# Rezoning Transportation Analysis

Petition Number: #2022-106

Date	Description
11-28-22	First Review (TM)
01-25-23	Second Review (TM)

**REZONING SITE PLAN**

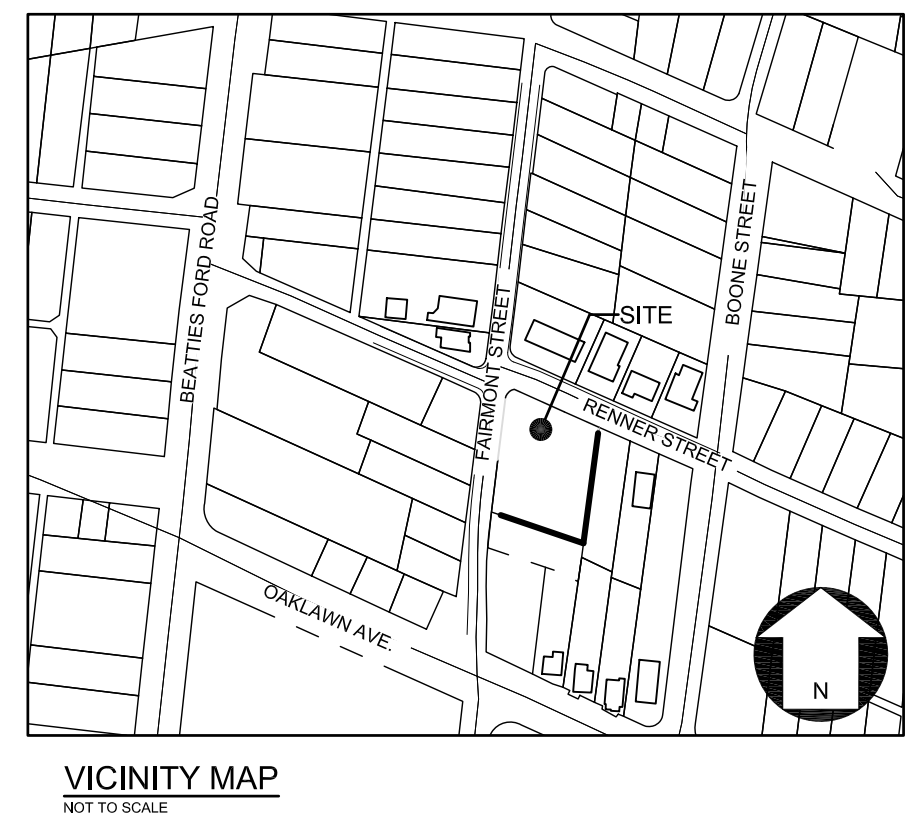
~~A Traffic Impact Study (TIS) is not necessary for the complete review of this petition due to the site generating less than 2,500 daily trips. If during the permitting process the site generates more than 2,500 daily trips, then a traffic study will be required.~~
3. ~~Revise site plan and conditional note(s) to commit to dedicate 28 feet of right of way from the road centerline. The site plan shall label and dimension the right of way from the road centerline.~~
4. Revise conditional note(s) to commit to construct an 8-foot planting strip, and 8-foot sidewalk on Renner Street and Fairmont Street per Chapter 19. The site plan shall label and dimension both items from the back of curb and gutter and road centerline.

**Clarifying Comment (01-25-23):** Revise site plan and conditional note(s) by showing sidewalk on the site plan and add a conditional note committing to this improvement.
5. ~~Site plan and conditional note(s) revisions are needed to commit to dedicating ROW in order to realign the existing intersection of Renner Street and Fairmont Street. Realignment of Renner Street at the intersection to be coordinated with CDOT.~~
6. ~~A site plan note(s) specifying dedication and fee simple conveyance of all rights of way to the City before the site's first building certificate of occupancy is issued as needed. CDOT requests rights-of-way set at 2' behind back of sidewalk where feasible.~~

**Additional Comment (01-25-23):** Remove language from conditional note 4 under transportation notes.
